CDR-21-013

C202

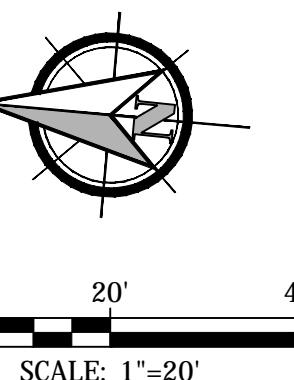
doesn't match plans
